DECISION DELEGATED TO DEVELOPMENT MANAGER

Application No: H09-0192-20 **Applicant:** Mr K Vaughan
Proposal: Erection of 3 bed detached house with on site parking
Location: Land At Holbeach Drove Gate (Site On Corner Of Holbeach Drove & B1166) Holbeach Drove
Terminal Date: 23rd April 2020

SITE AND LOCATION

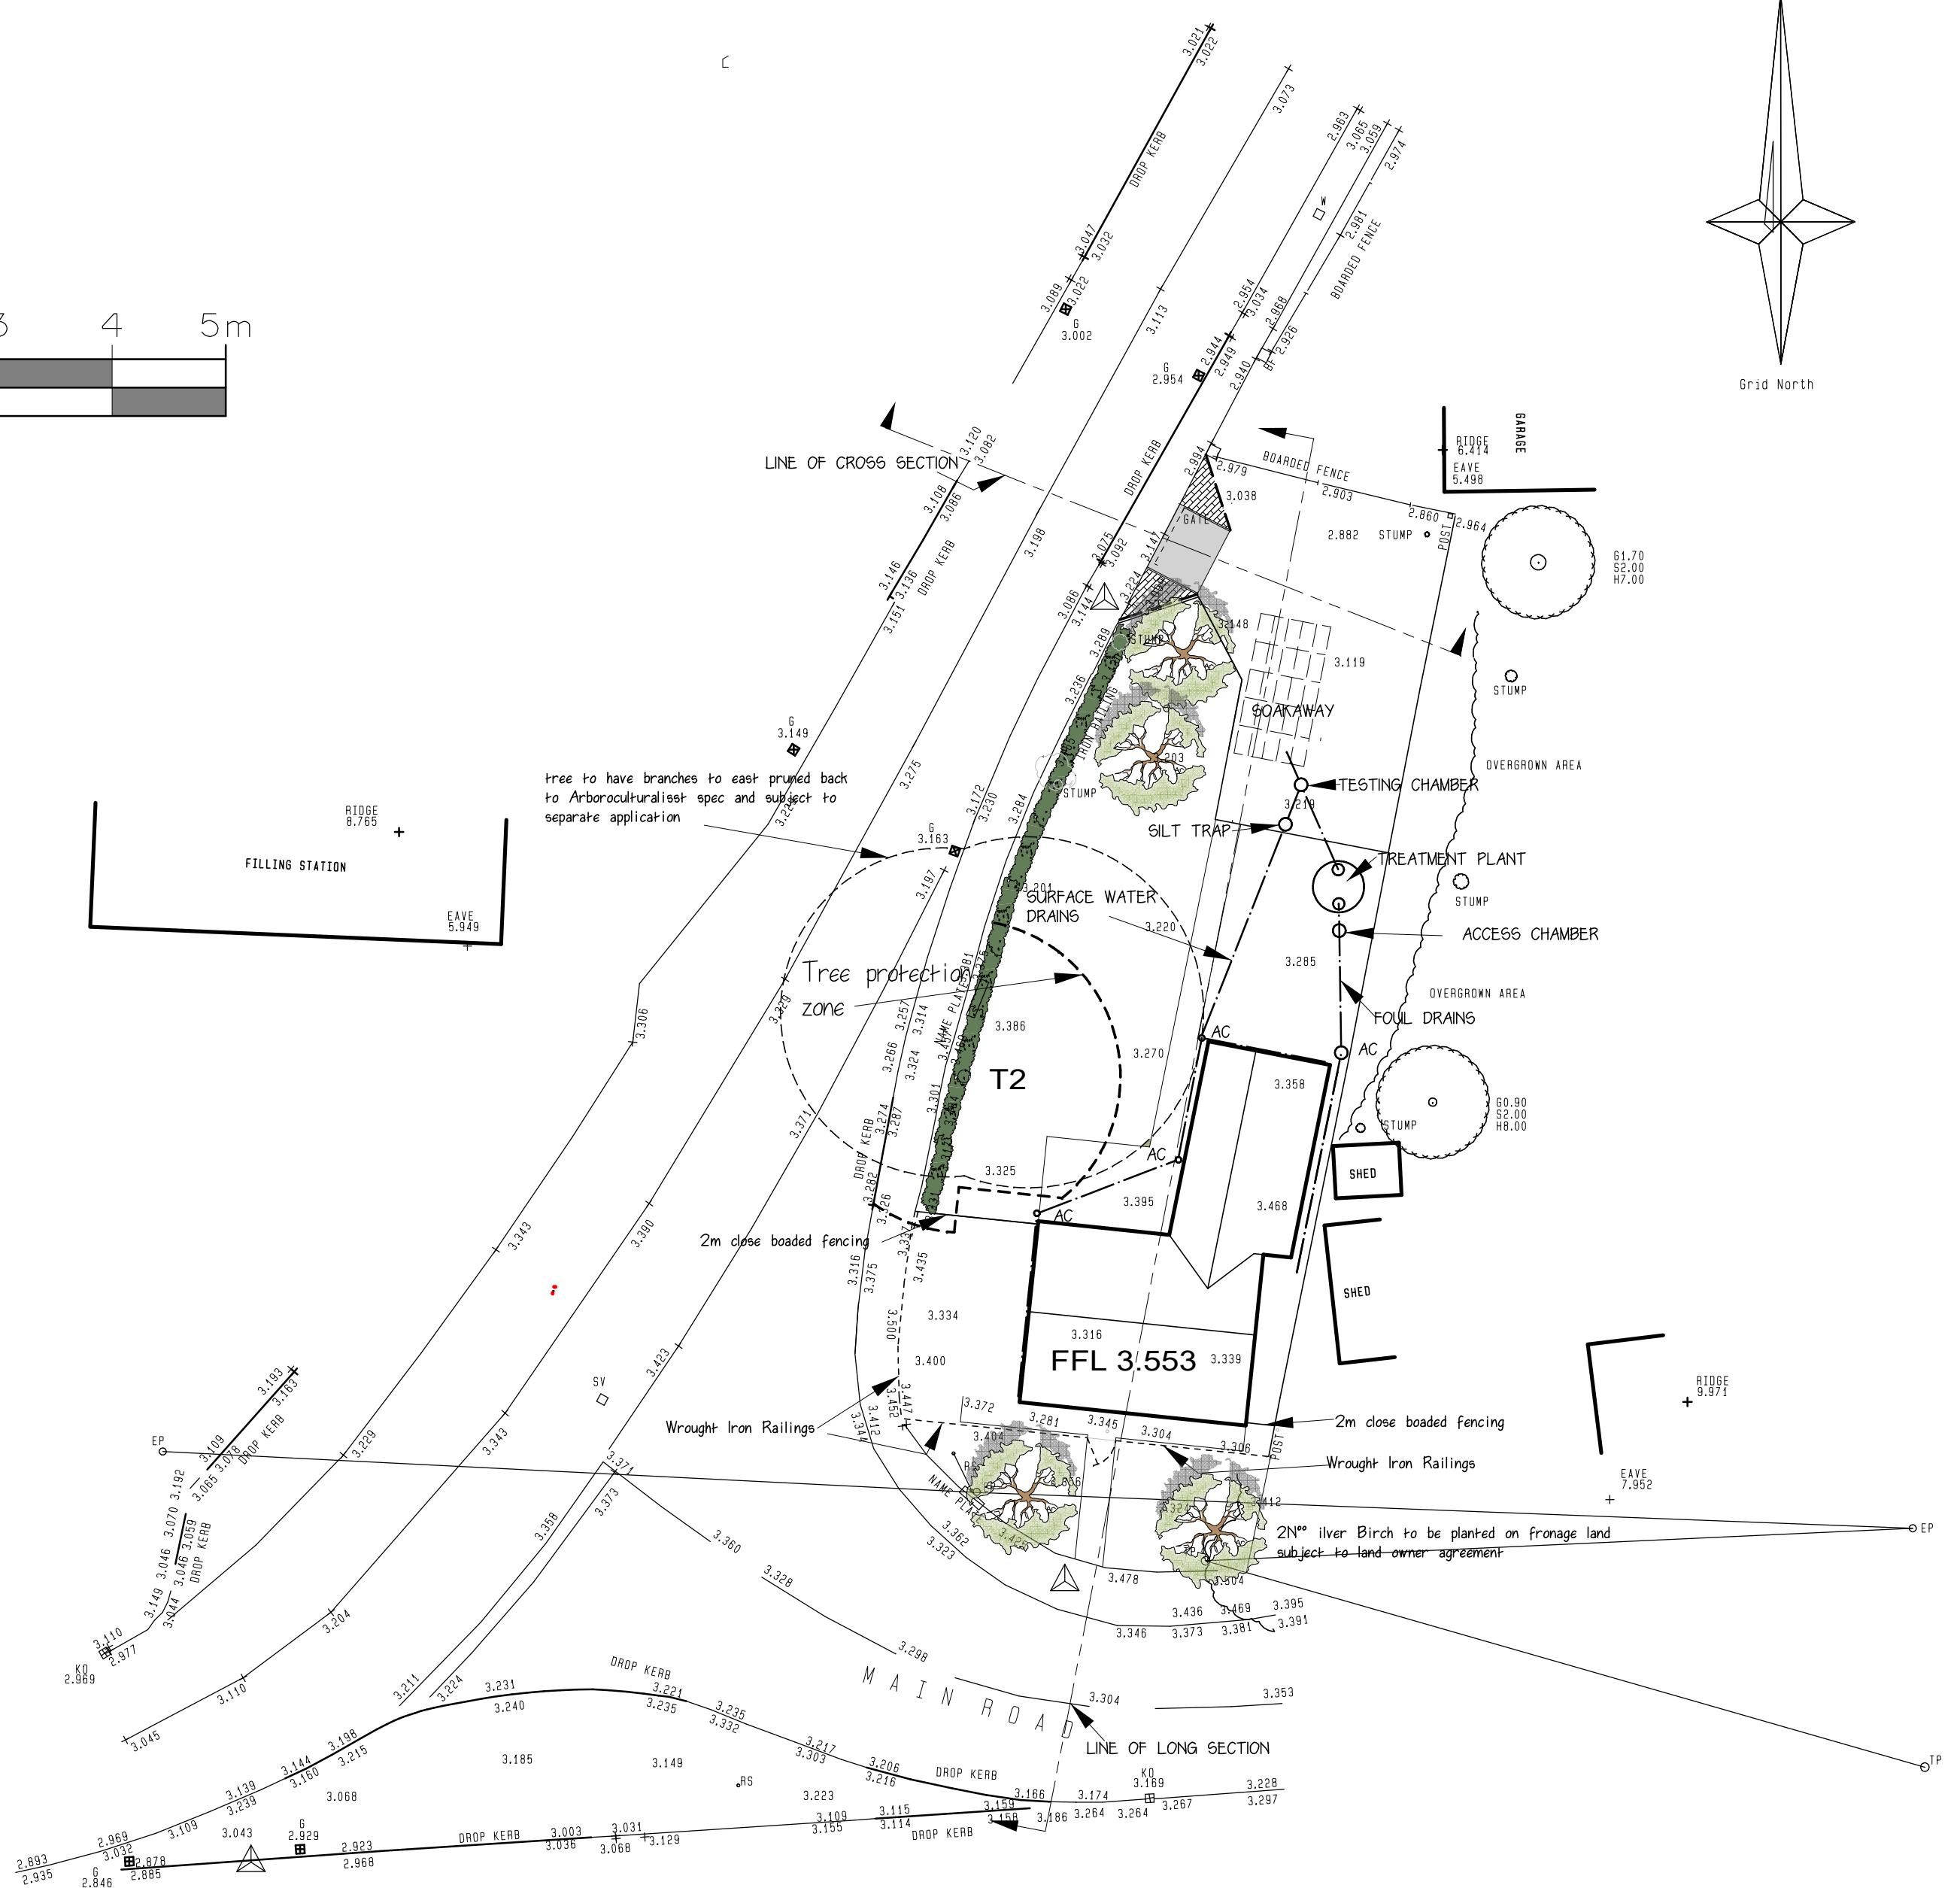
Whilst the heights remain across the elevations of the house, the width has been reduced 2 metres up to 8 metres. As a result of that, the region of separation distances between the development and Drove Road to the west has been increased from 1.19-2.26 metres to 3.99-4.26 metres.

The site is a corner plot adjoining a wide Y-junction. Thus, the views to the proposed house are significant from Holbeach Drove Gate/B1168 coming from the west and north and from the east (Drove Road). Taking this into account, the width reduction will certainly lessen the impact of the proposed dwelling from Holbeach Drove Gate/B1168 whichever the direction is on this road. However, given no alterations have been proposed for the separation distances with the southern boundary, the development will still appear prominent from Drove Road (east).

However, the proposal fails to prevent any significant harm upon the local character of the area. The design and appearance of the house itself is not out of character. Albeit the width reduction, the position of the intended house remains in close proximity to Drove Road which will arguably increase its prominence on the wider street scene, particularly when viewed from Drove Road to the east.
